# Rezoning Transportation Analysis

Petition Number: #2022-105

## Revision Log:

Date	Description
11-28-22	First Review (PM)
12-22-22	Second Review (DR)
2-22-23	Third Review (JP)

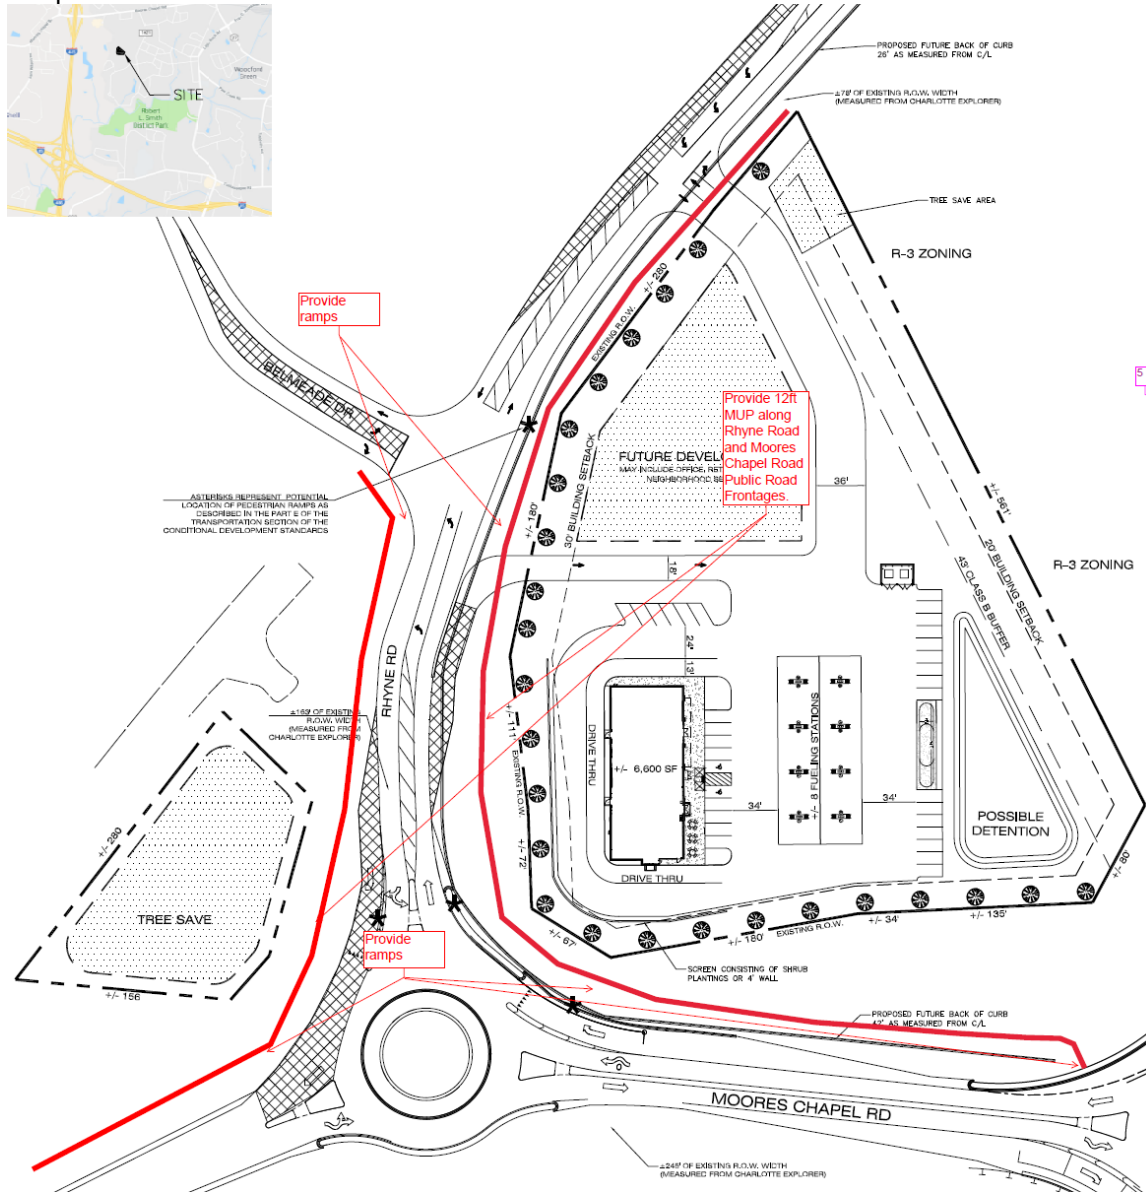
### 2. Revise site plan conditional note in the transportation section letter e. for Southbound I-485 Off Ramp to say, "Extend existing southbound right turn lane to provide 400' of storage and appropriate taper."

**REWORD:**

Extend SBR to provide 400' of storage and appropriate taper.

Existing SBR is 200'.

**Clarifying Comment from 12/22/2022:** Reword improvement at Southbound I-485 Off-Ramp to what is shown in the picture above.

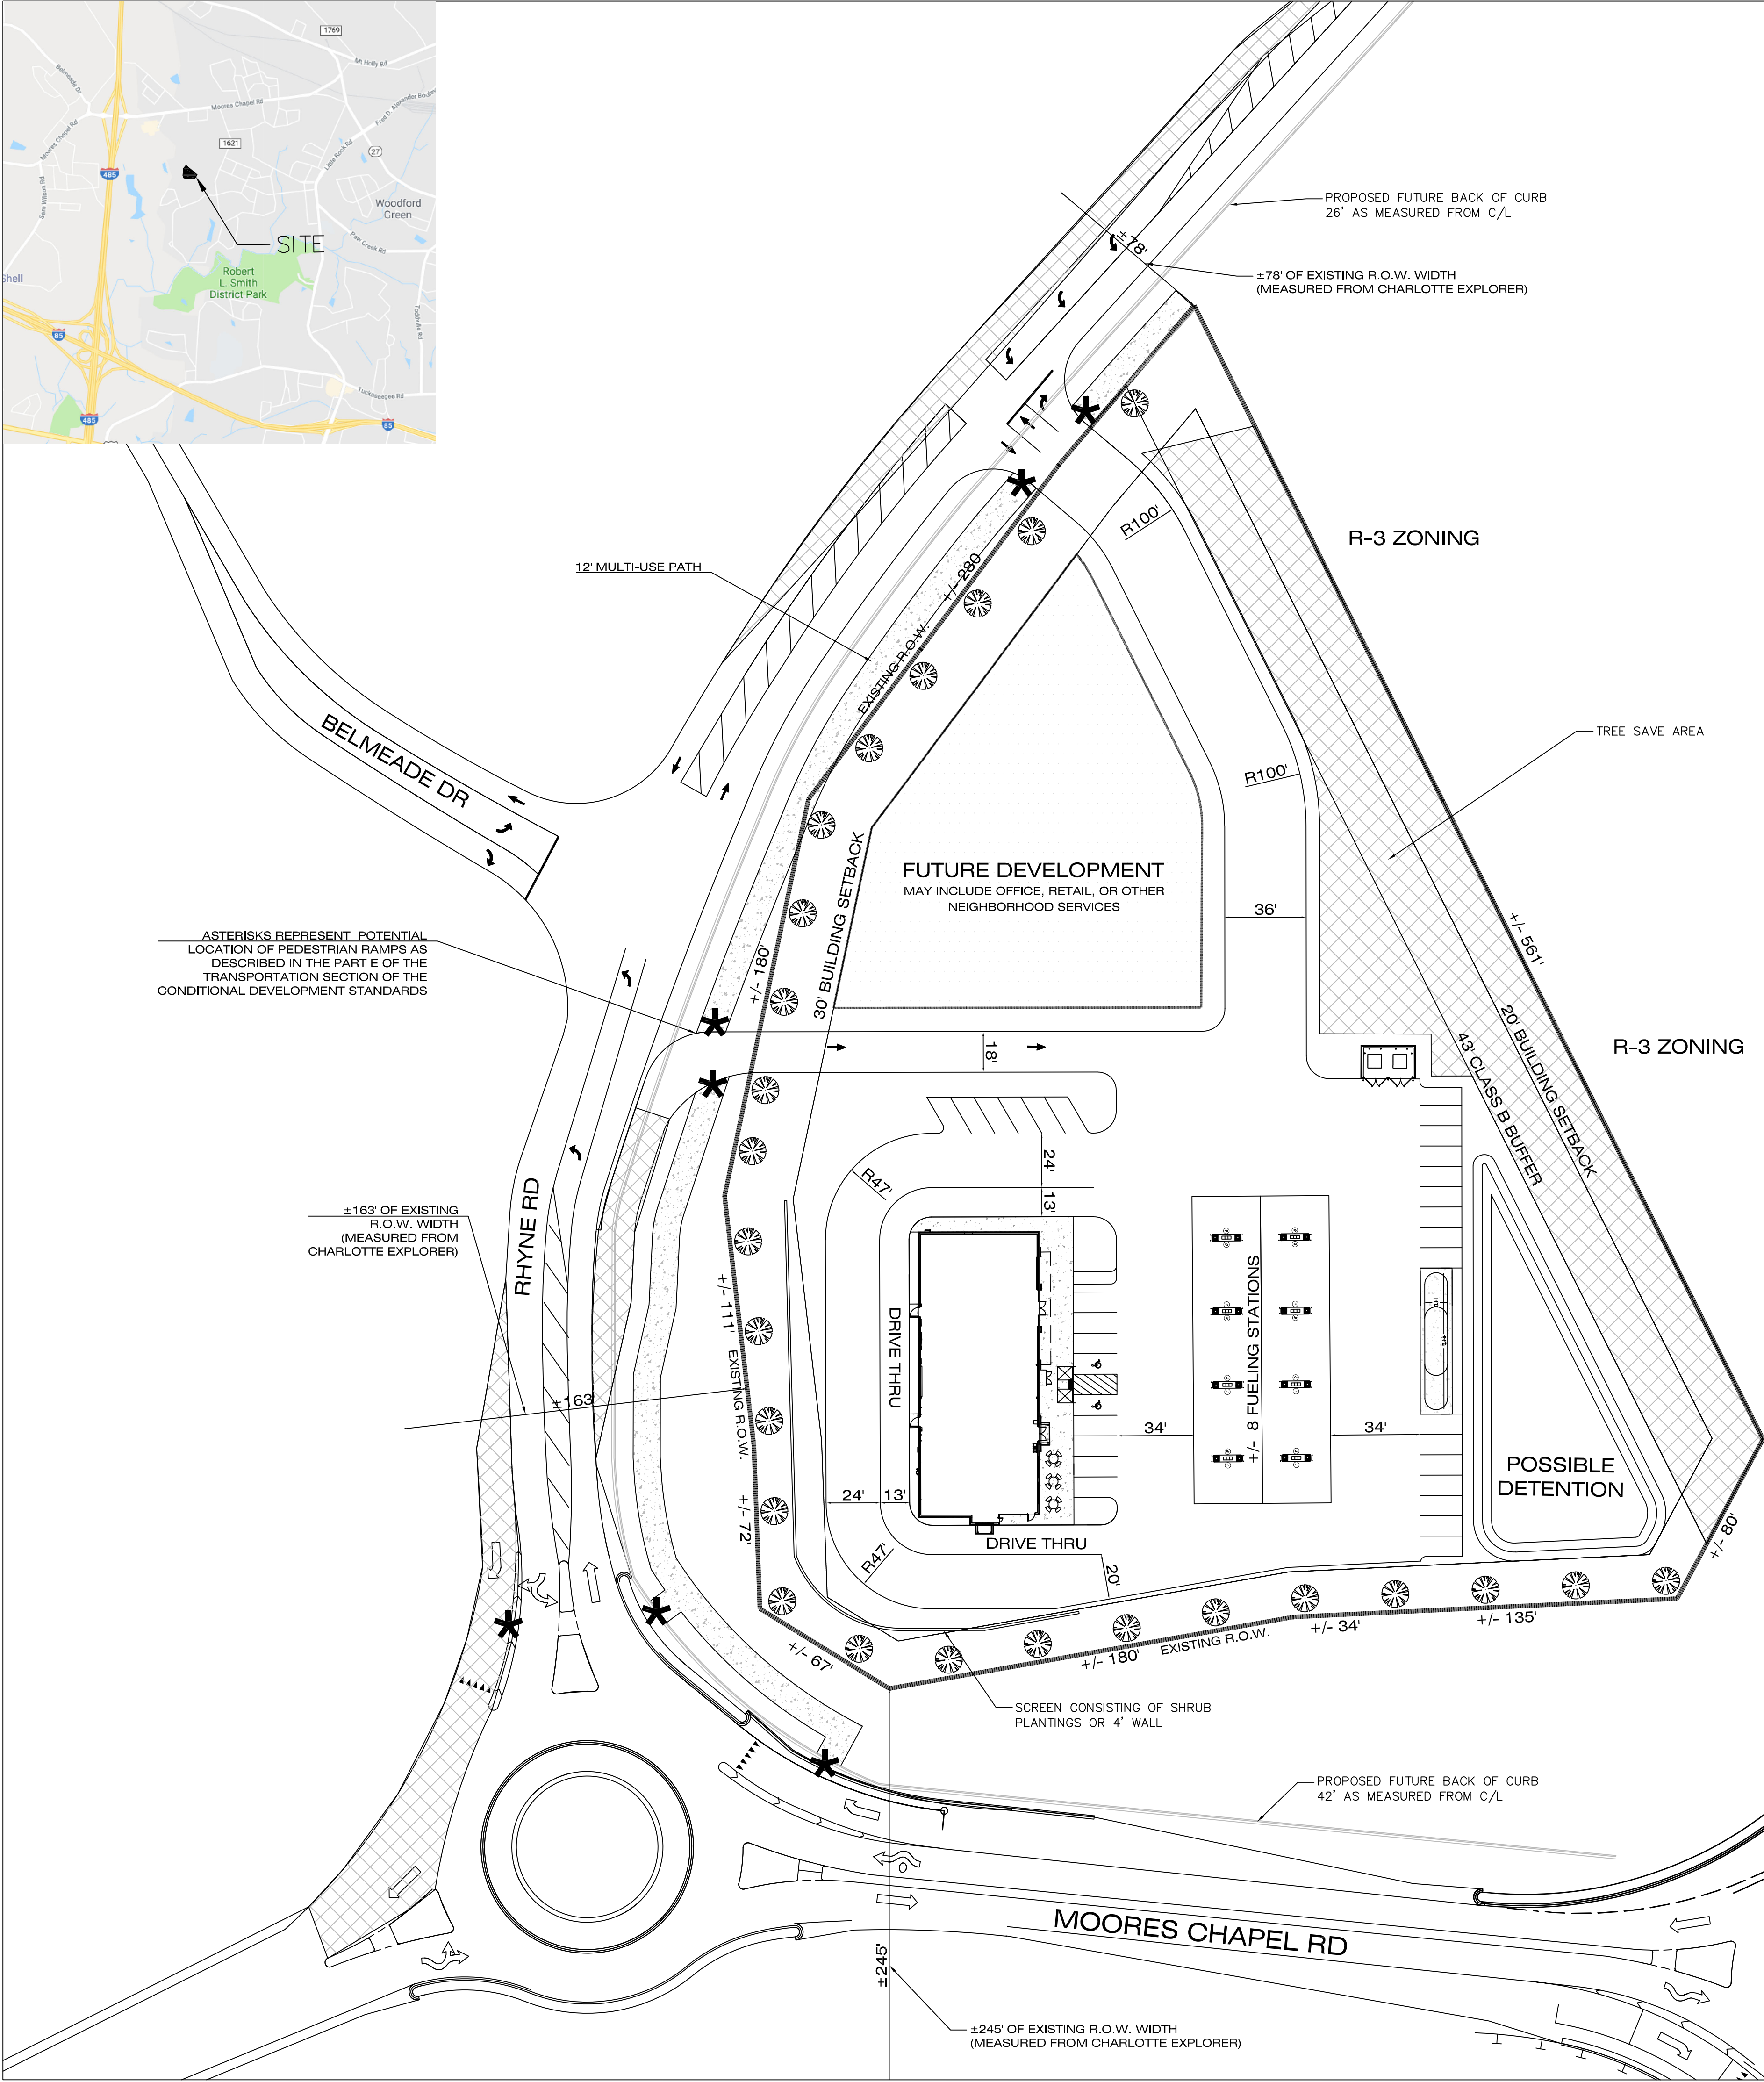
3. Revise site plan and conditional note(s) to provide 12-foot multi-use path and 8-foot planting strip along all public road frontages (Moore's Chapel Road, Rhyme Road, Belmeade Drive). Revise the ramp locations and conditional note Transportation Note E to include the additional ramps that will be required. Provide SUE located 2-feet behind sidewalk if located outside of the ROW. Add conditional note to coordinate Control of Access Break with NCDOT for proposed multi-use path along Moore's Chapel Road.

4. Revise site plan and conditional notes to provide curb and gutter along the public roads that front the proposed tree save parcel. The minimum distance to the back of curb and gutter is 19-feet from the centerline of Rhyme Road and 30-feet from the centerline of Moore's Chapel Road.

**Clarifying Comment from 12/22/2022:** Label and dimension streetscape along all public road frontages (12-foot multi-use path and 8-foot planting strip). Revise ramp locations as shown above and update conditional note to incorporate additional ramps. Provide SUE located 2-feet behind sidewalk if located outside of the ROW. Add conditional note to coordinate Control of Access Break with NCDOT for proposed multi-use path along Moore's Chapel Road.

**Clarifying Comment from 2/22/2023:** If the tree save area to the west of Rhyme Road was removed from the rezoning, MUP will no longer be required on the west side of Rhyme Road. The MUP along Moore's Chapel is required for the rezoning petition. If NCDOT does not allow the MUP during site plan permitting, it will not be required to be constructed.
